Supplementary Response to Submissions Report
New Primary School at Googong
SSD-10326042

On behalf of
NSW Department of Education
November 2021

SITE ANALYSIS PLAN

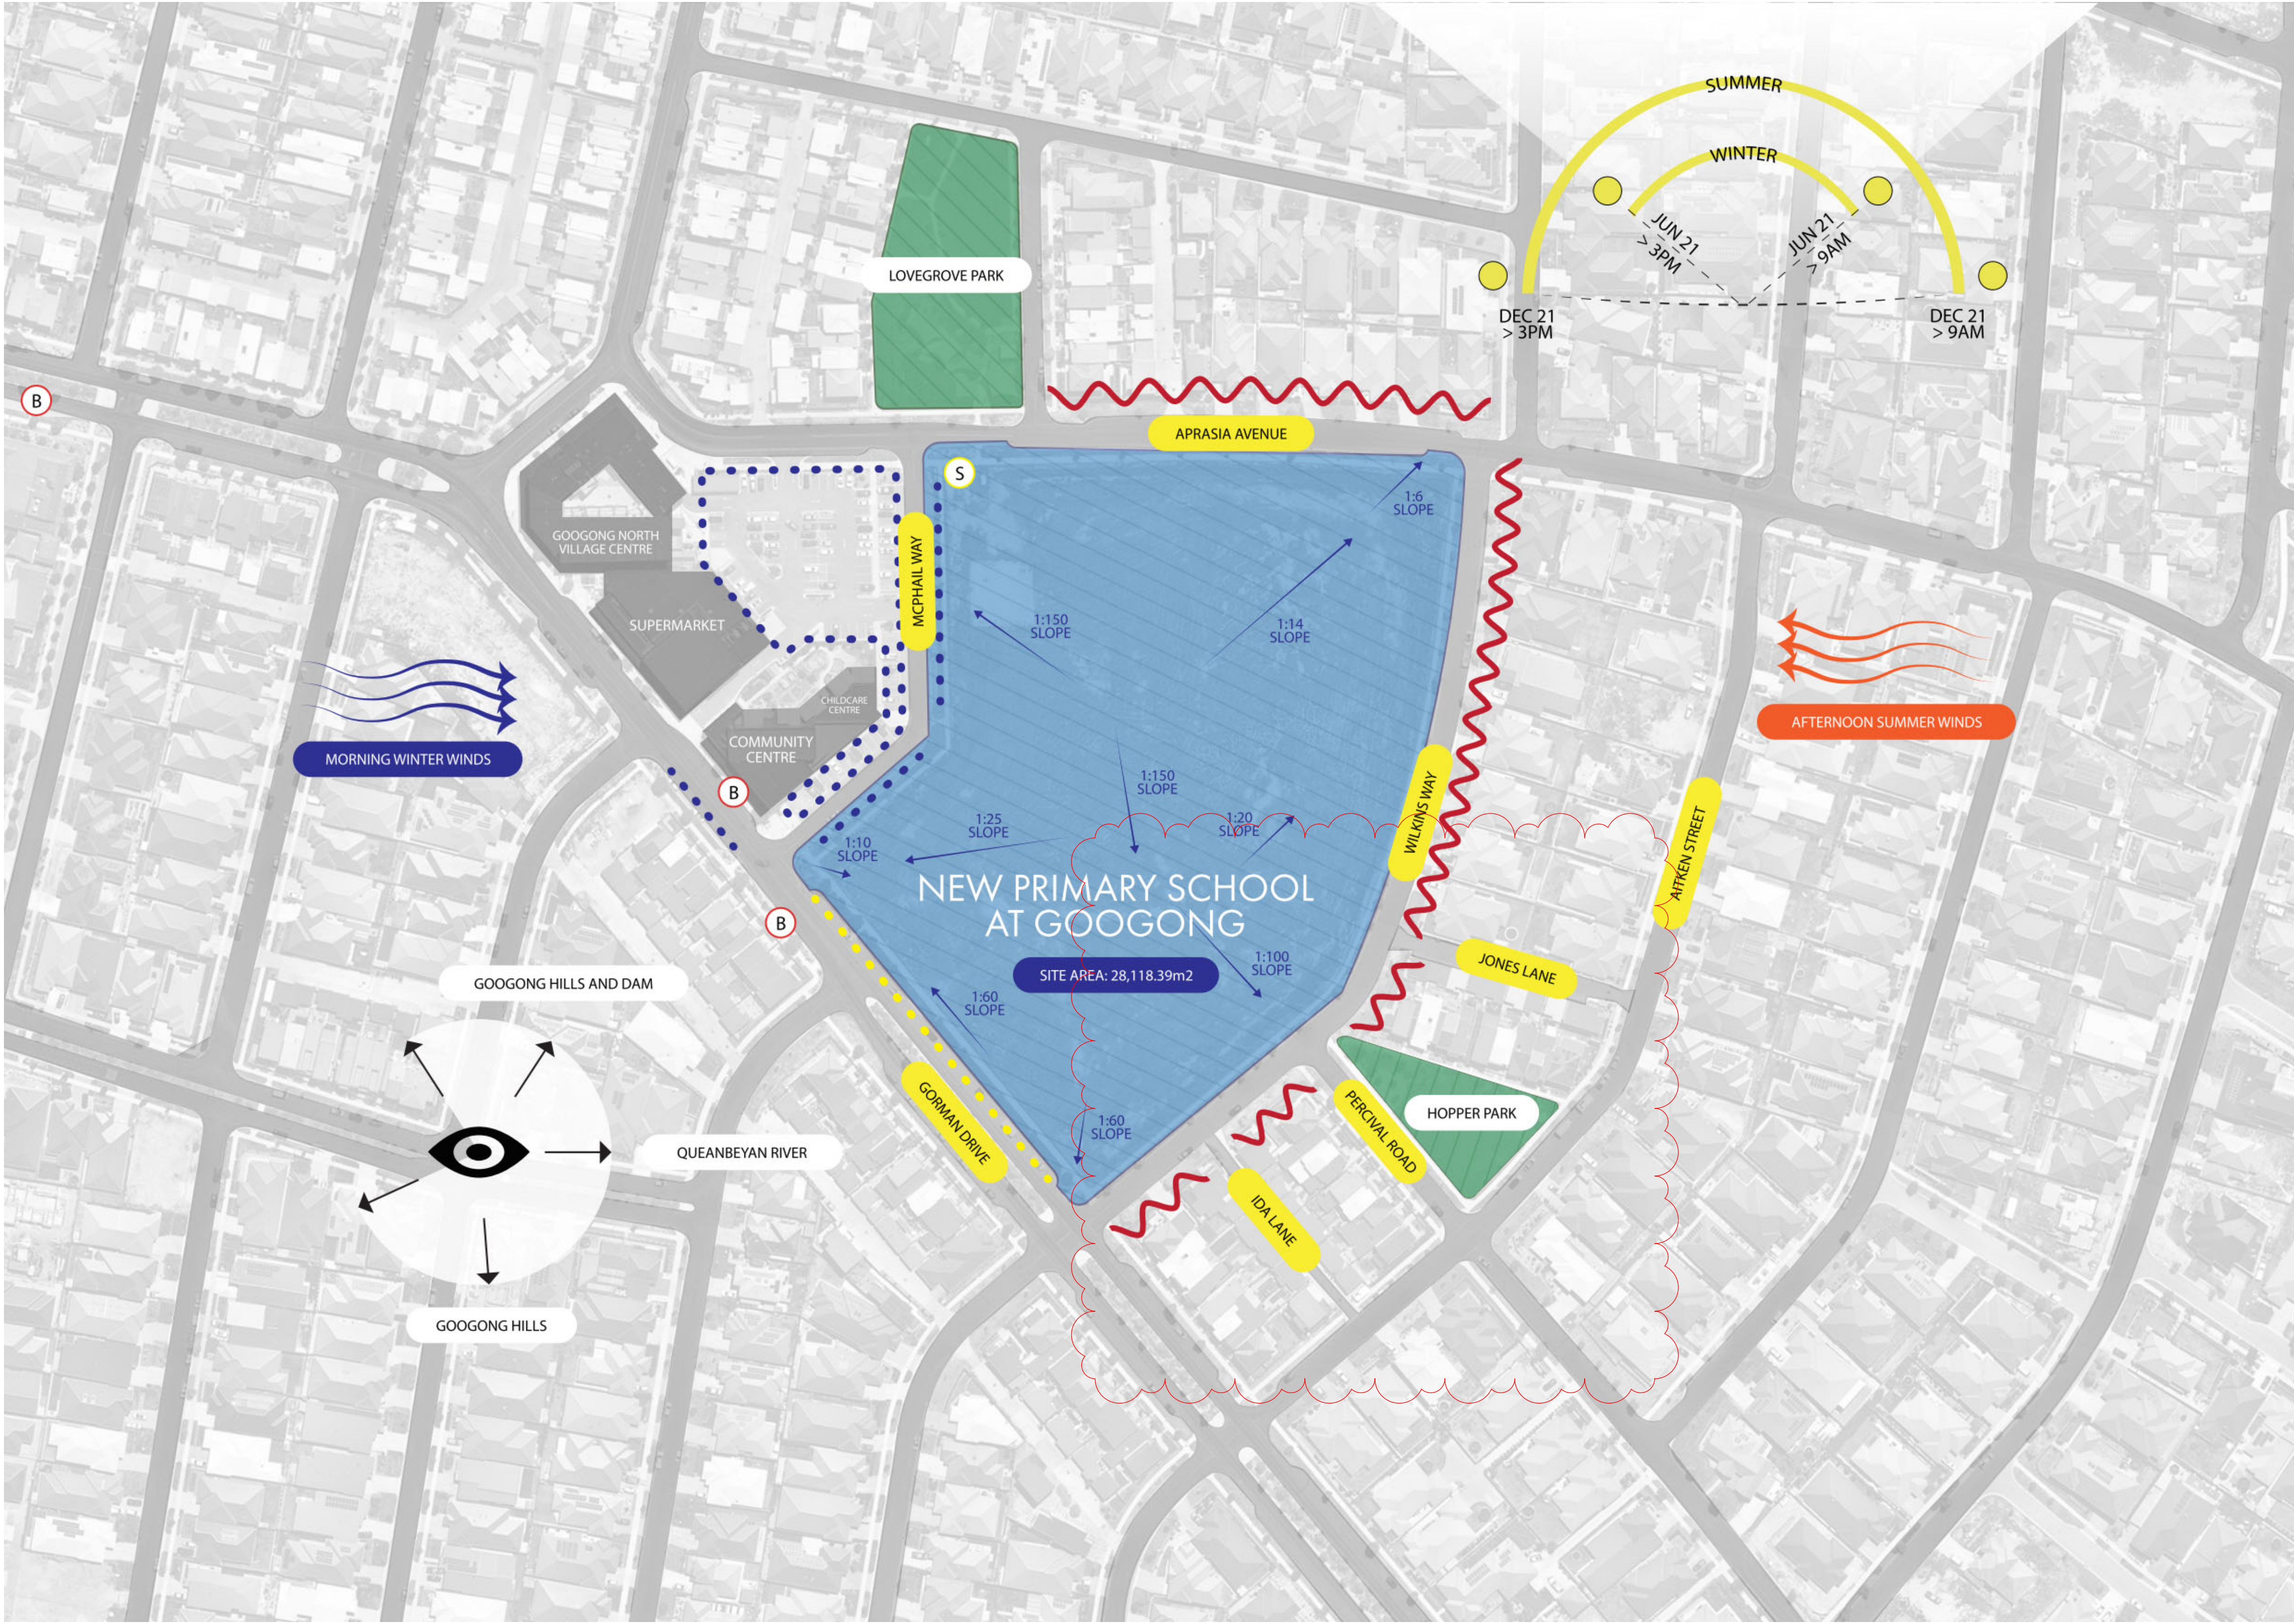
Submission ID	Summary of issues raised	Response
C. Notting Googong, NSW (Objects)	Drawings contain inaccuracies in regard to road labelling.	<p>We acknowledge that the architectural site plan, site analysis plan and shadow diagrams contained labelling errors/omissions in regard to Percival Road, Ida Lane and Jones Lane. The plans have been updated to correct these errors/omissions (see Appendix C).</p> <p>The errors/omissions were clerical in nature and did not substantively affect the design or assessment of the project. We also consider that the errors/omissions were not seriously misleading and did not affect the public exhibition process substantially.</p>
	Revised kiss-and-ride and new pedestrian entries will violate privacy of residents along Wilkins Way, Hopper Walk and Percival Road	<p>The relocated kiss-and-ride may increase traffic and pedestrian activity along Wilkins Way (primarily on the eastern side), but this activity will occur at street level in the public domain and primarily during school peak hours. Generally speaking, standard school vehicular and pedestrian traffic along local roads does not give rise to serious privacy impacts that require special mitigation.</p> <p>We note that the Wilkins Way kiss-and-ride location was assessed from a noise perspective as part of the Amended Proposal, and the assessment found that the impacts will be minor, manageable and consistent with the previous location along Aprasia Avenue in terms of general level of impact.</p>
